LAND AT CINDERS LANE
YAPTON

PROPOSED SITE ACCESS

STAGE 1 ROAD SAFETY AUDIT

DECEMBER 2016

SITE ACCESS ROAD VISIBILITY SPLAY (SCALE 1:200)

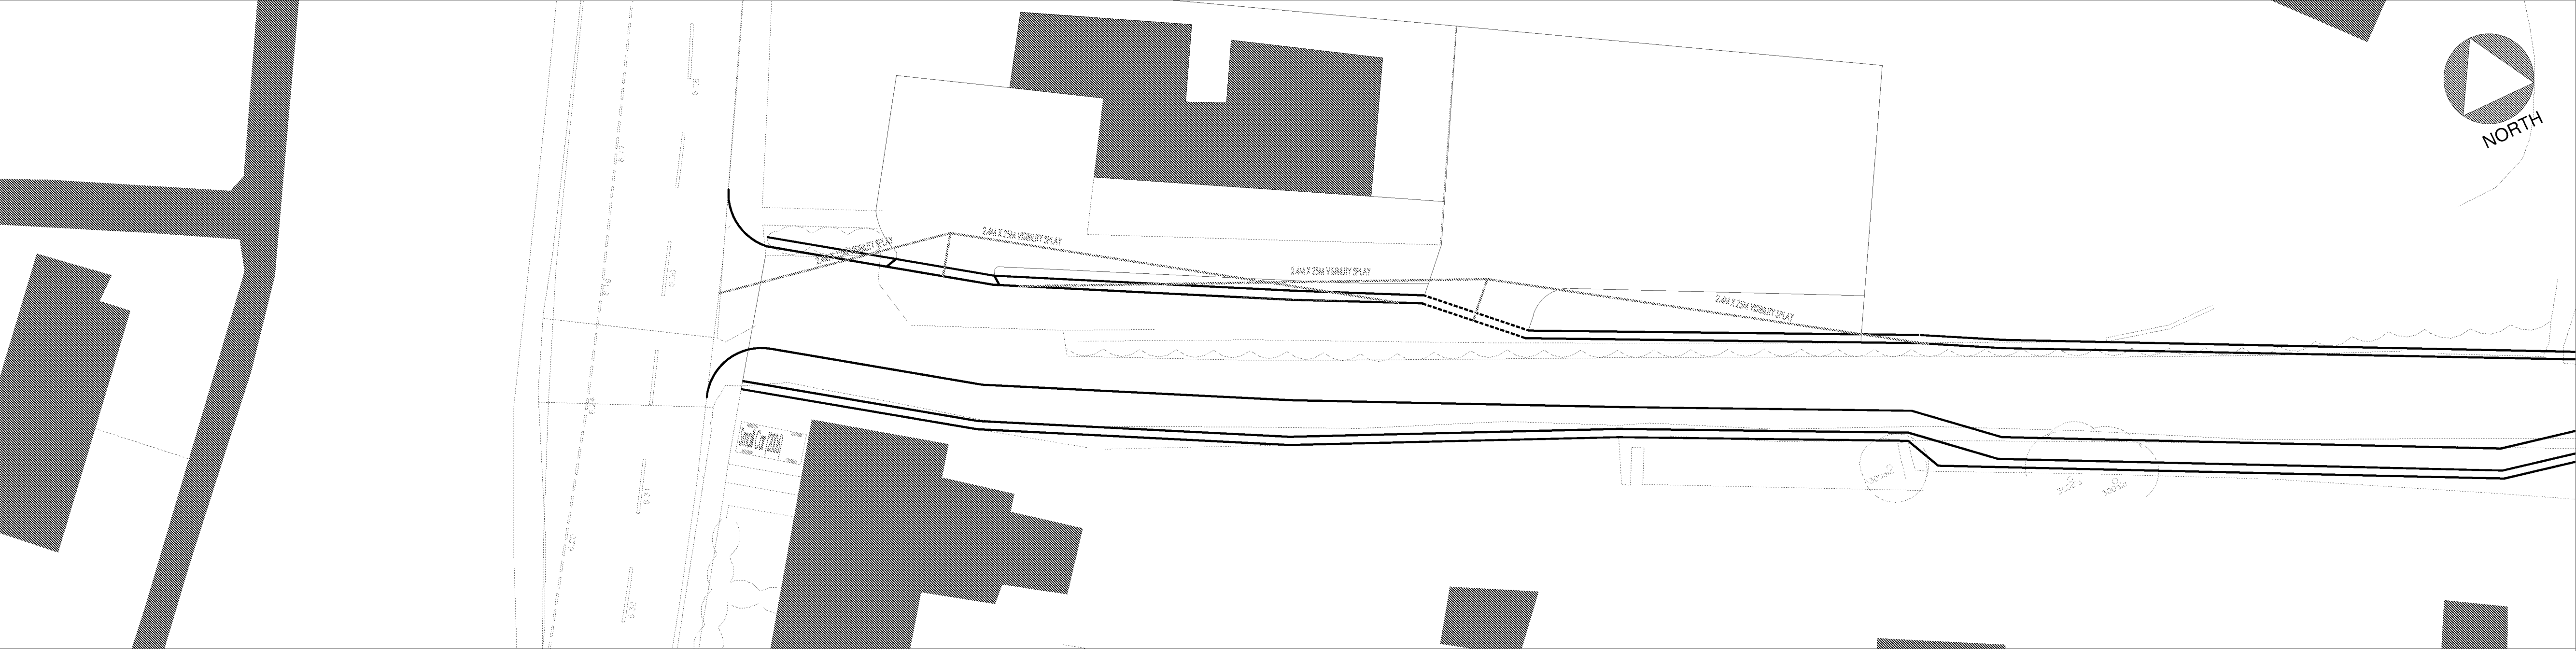
LOCATION: Proposed access

SUMMARY: Compromised visibility

At the time of the site visit parked vehicles were present either side of Cinders Lane. These vehicles would compromise the visibility from the development should they remain which could lead to vehicles turning from the Cinders Lane in front of through traffic resulting in collisions.

Ensure visibility splays are not compromised by parked vehicles.

Problem no. in safety audit report	Problem accepted (yes/no)	Recommended measure accepted (yes/no)	Alternative measure (detail description)
3.1	Y	N	Use all 'reasonable endeavours' to secure a TRO prohibiting parking on Bilsham Road for the extent of the visibility splays, during the day (such as 8am to 6pm) when the majority of vehicles movements generated by the proposed development would occur.
